Comments on the Applicant's D4 Submissions

This document sets out the comments by Cambridgeshire County Council (**CCC**) and Fenland District Council (**FDC**) (together, **the Councils**) on the Applicant's Deadline 4 (**D4**) submissions. The tables below set out the document in question that the Councils are commenting on, together with the relevant paragraph or reference number.

**Figure 3.19i**  
**New Bridge Lane access proposal**

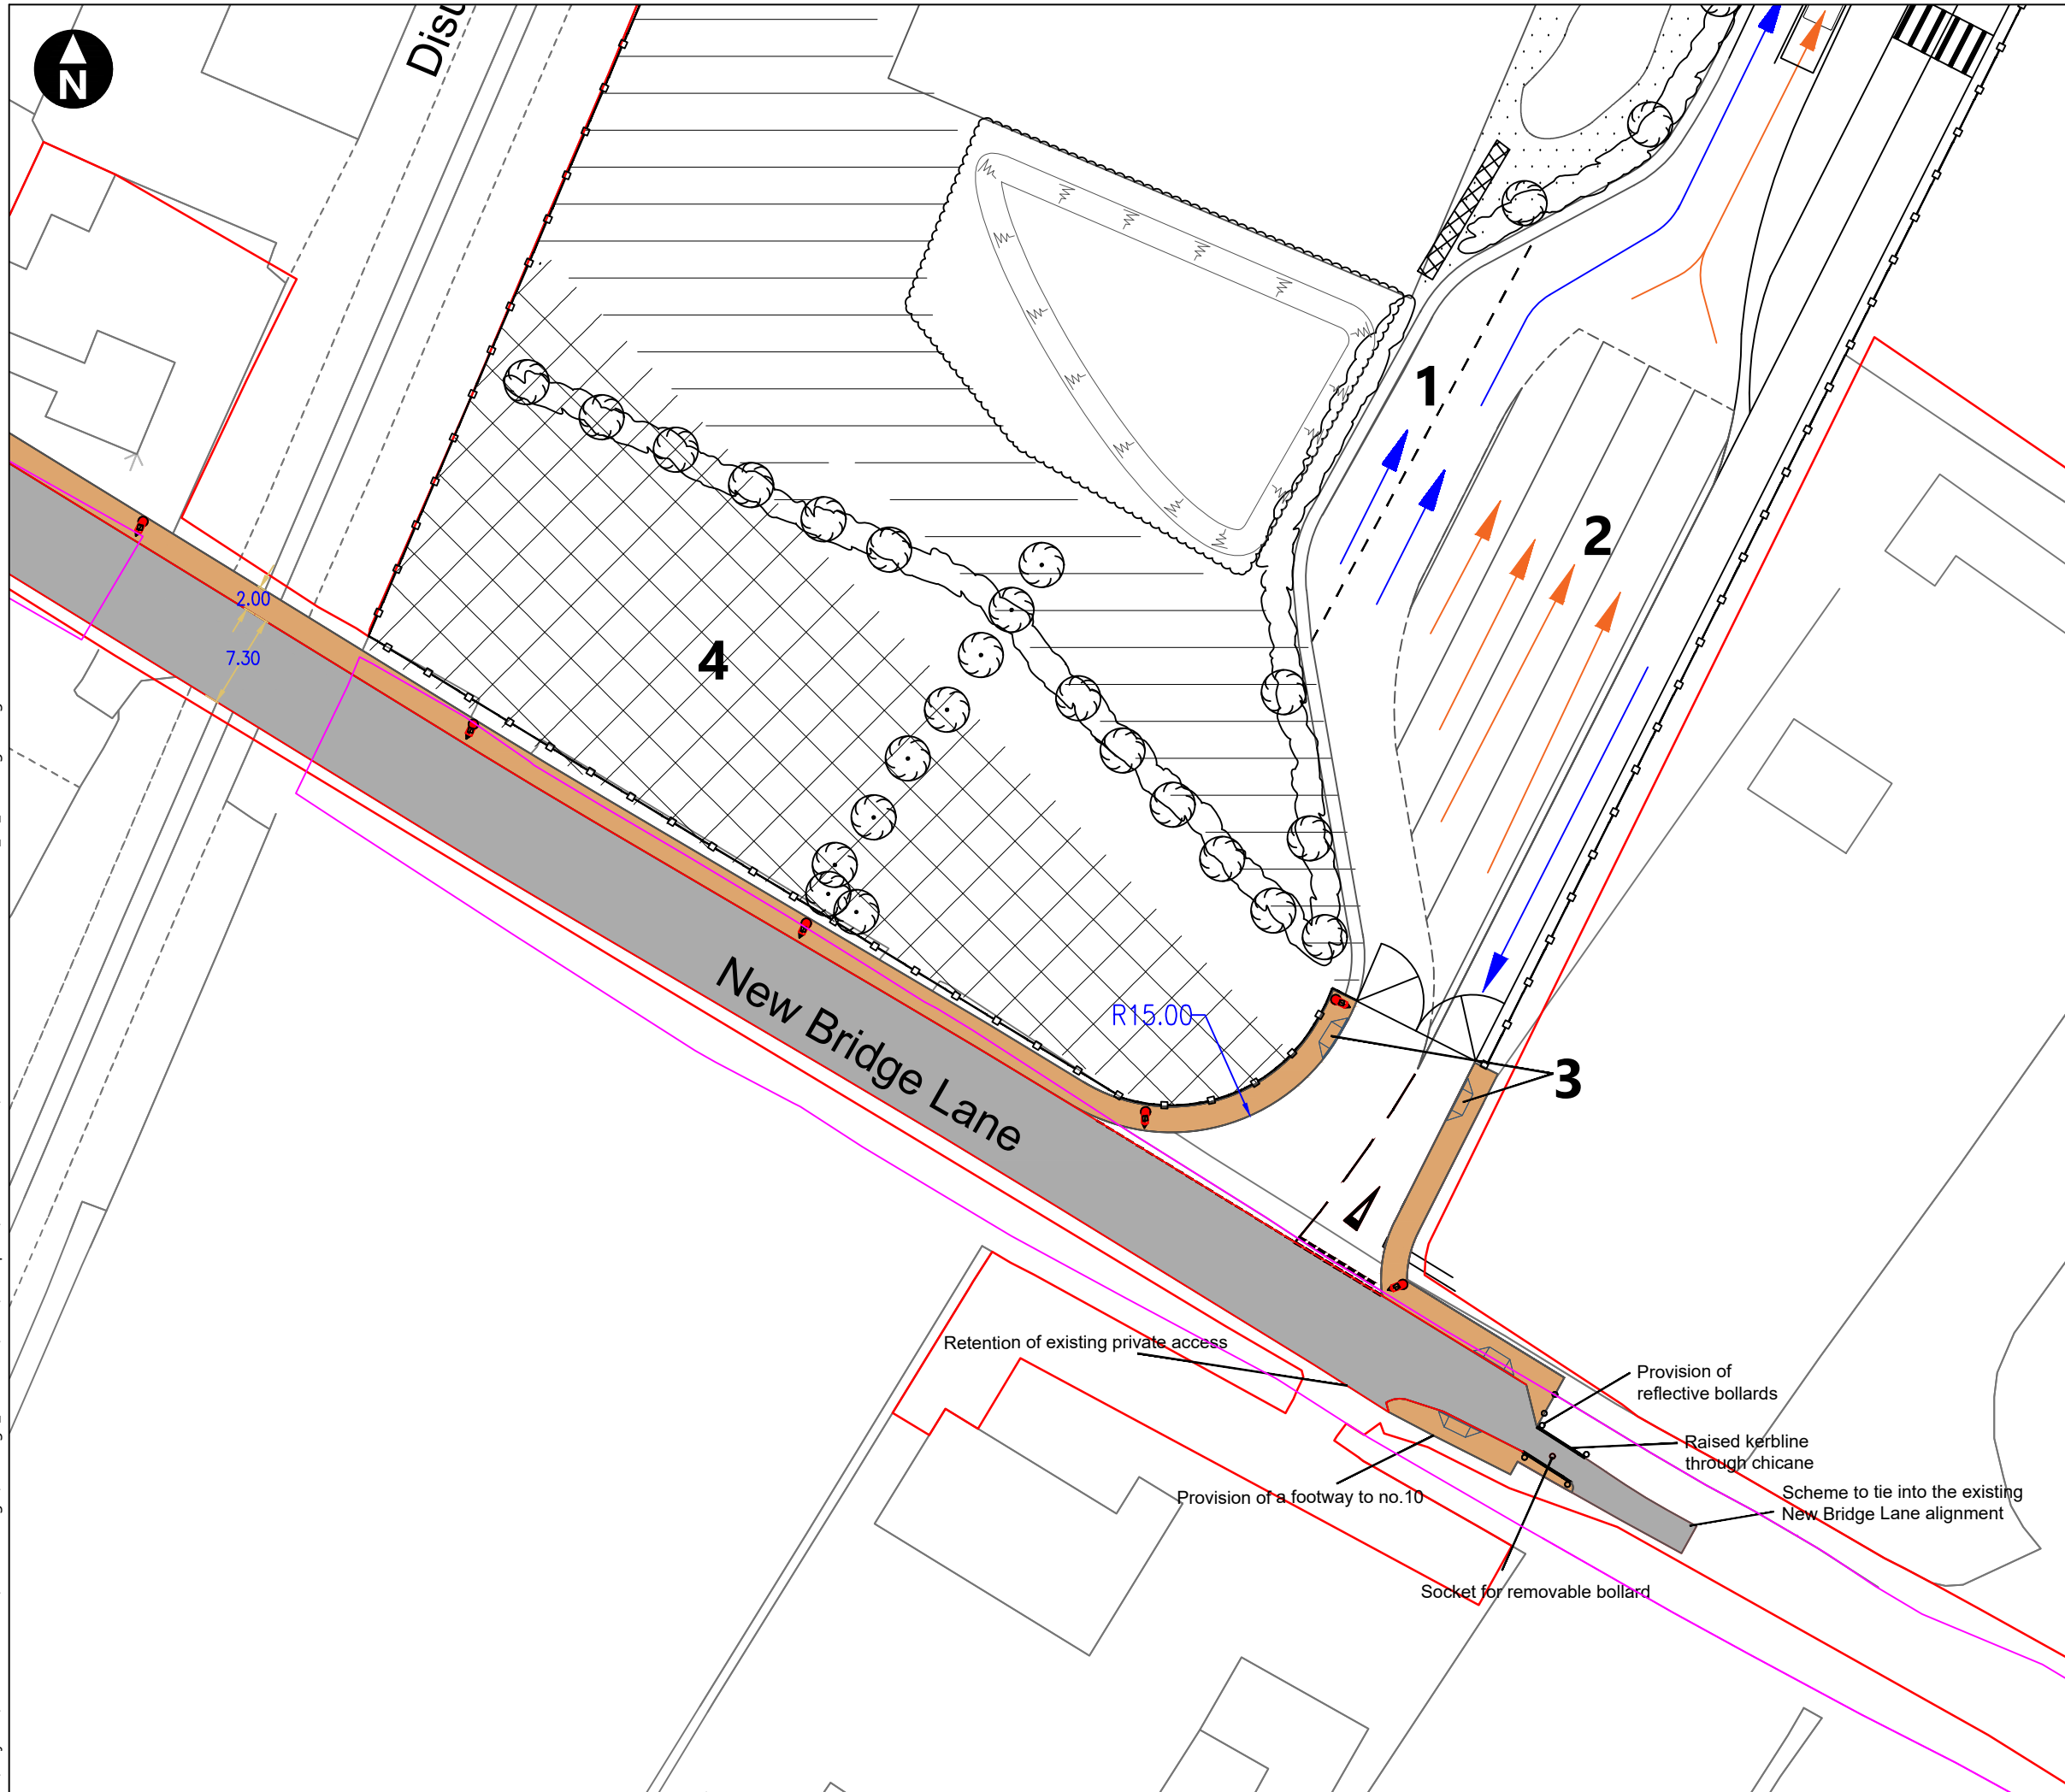
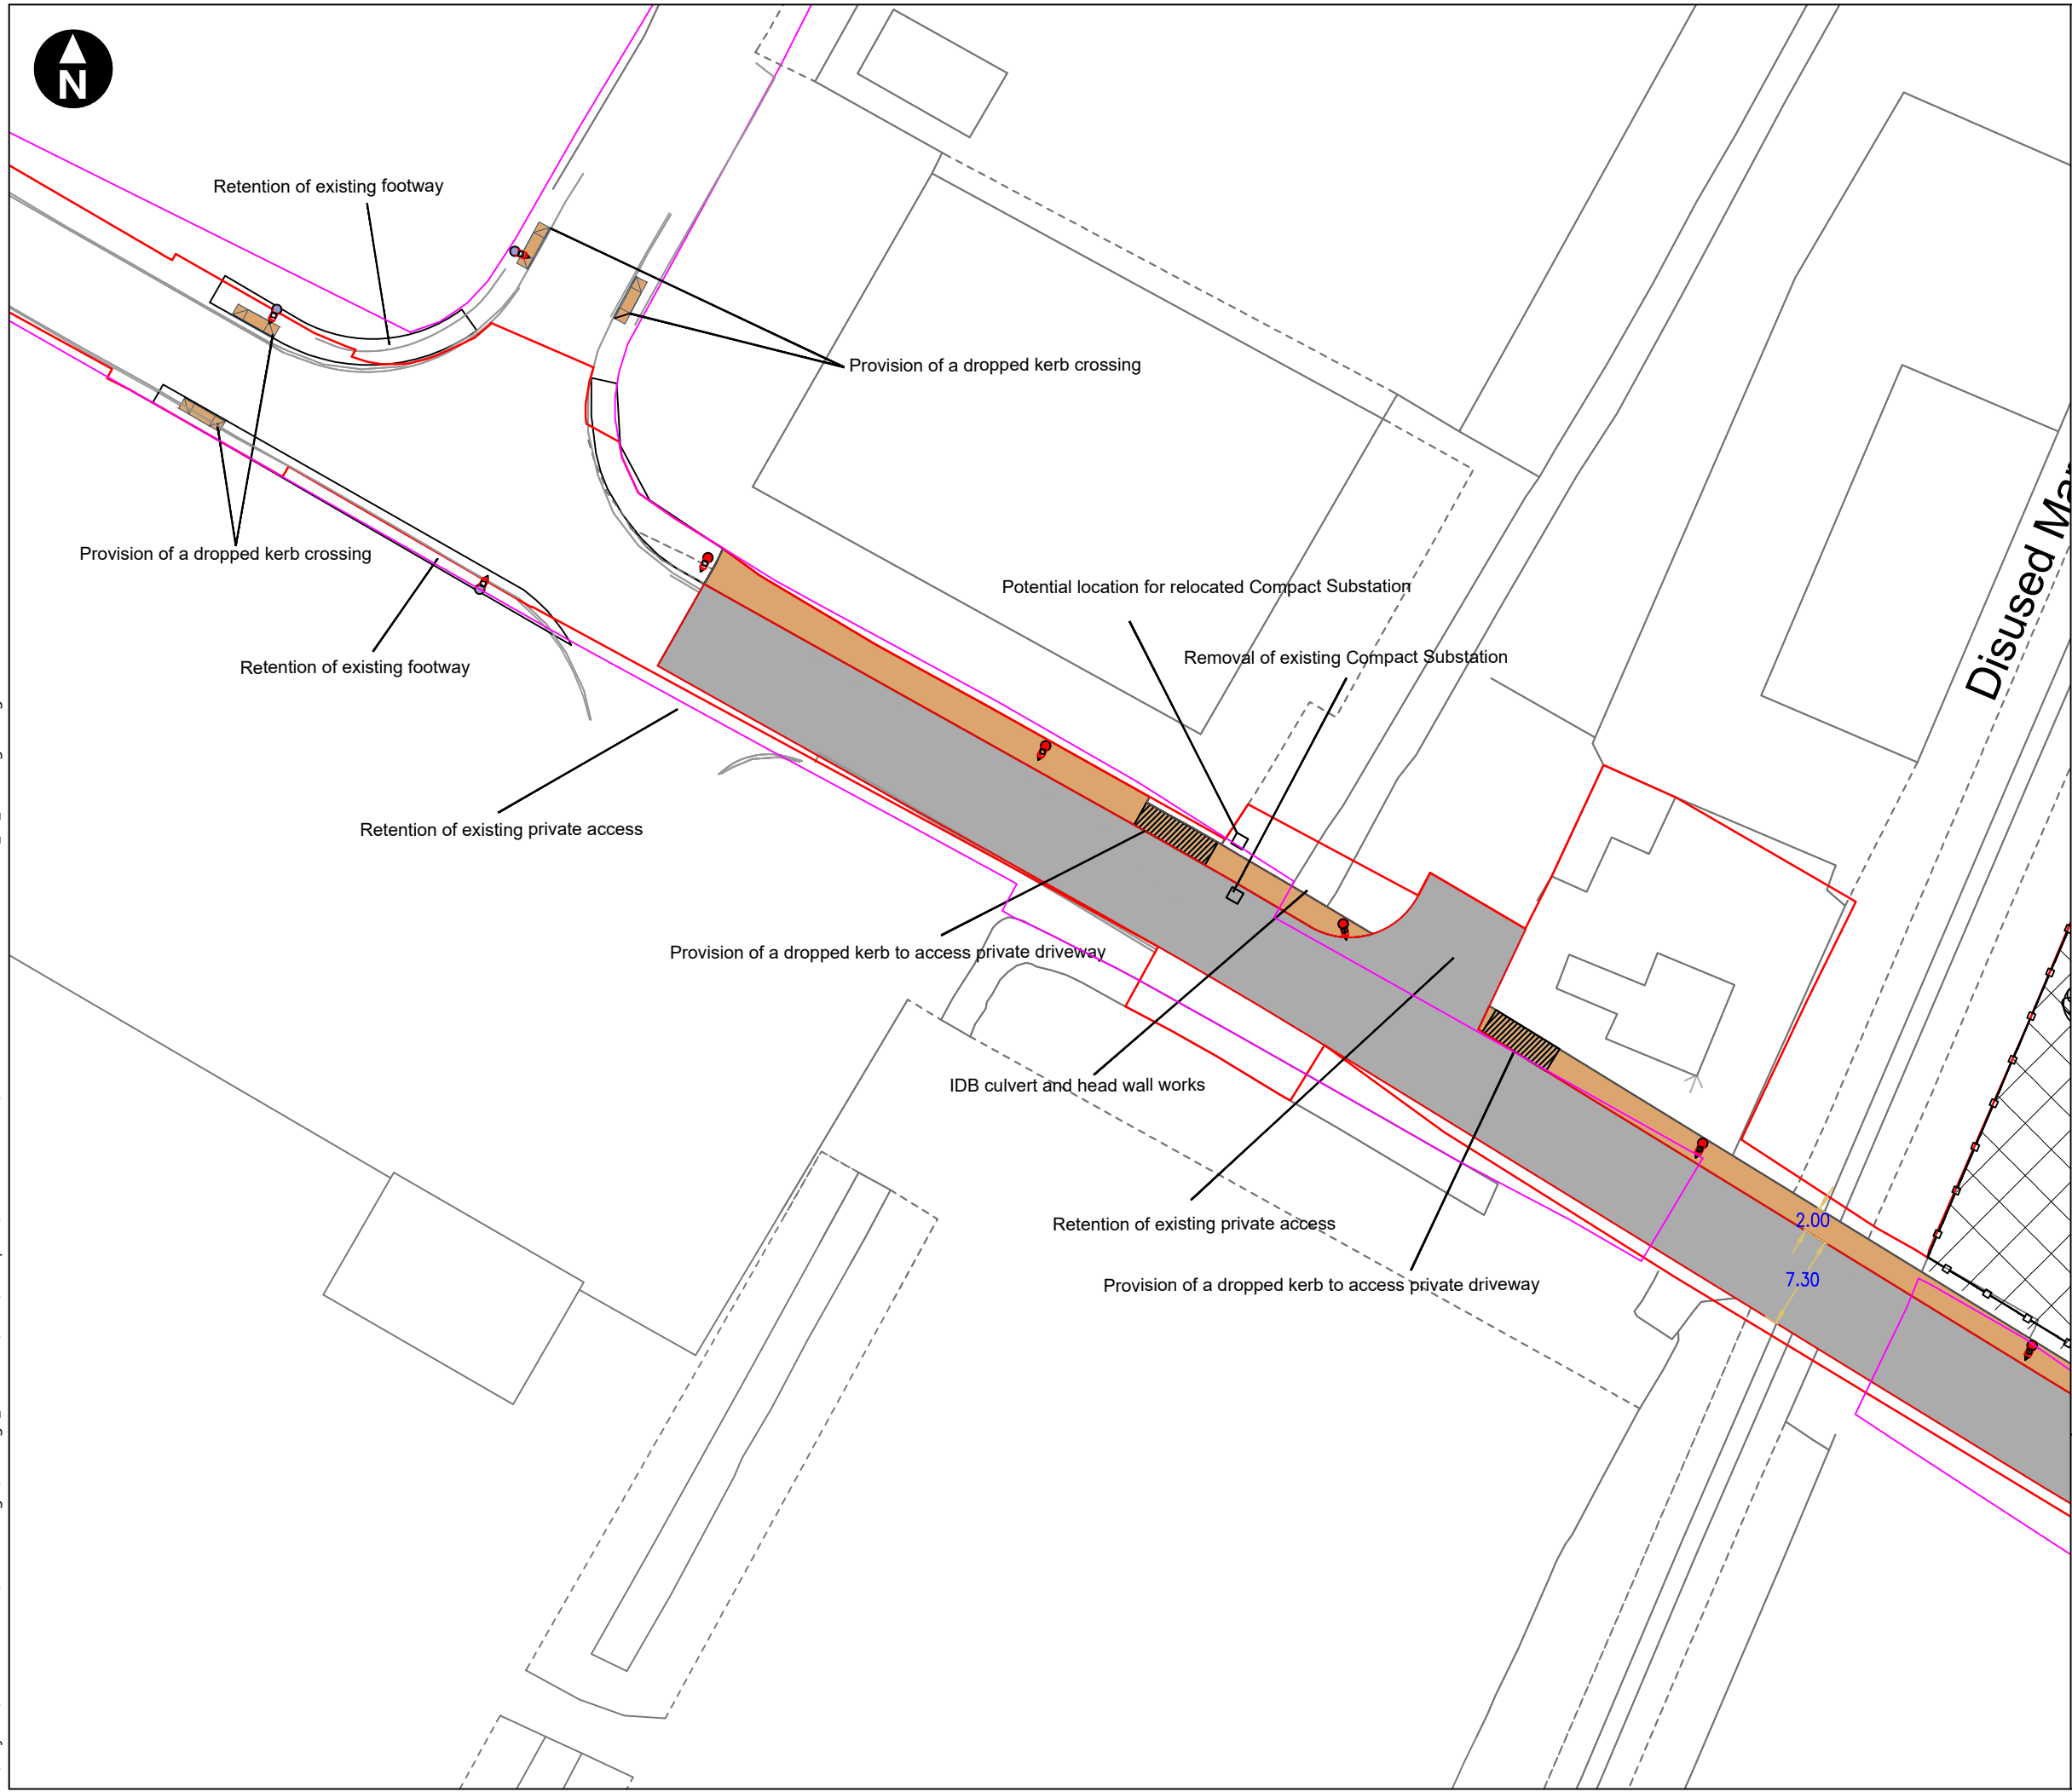
<i>Noise and Vibration</i>		
Impact on NMUs and local communities	Pages 18-19	The Councils note the Applicant's response. The Councils remain of the view that NMUs will experience more noise and vibration during operation of the Proposed Development than is currently the case along New Bridge Lane, due to the additional level of HGV traffic that will be generated. The Councils point out that the limited mitigation possible along New Bridge Lane is one of the reasons that the Councils seek the mitigation package set out in its response within document CLA.D5.EXQ2.R , to be submitted at Deadline 5.
<i>Traffic and Transport</i>		
Highways Asset Management: Construction Phase Impact on NMUs and other rights of access	Page 24	The Councils refer to their response within document CLA.D5.EXQ2.R , ExQ2 TT.2.3, to be submitted at Deadline 5. With regard to the bollard, the Councils note that there will be provision with the DCO for a TRO and that this matter is under discussion.
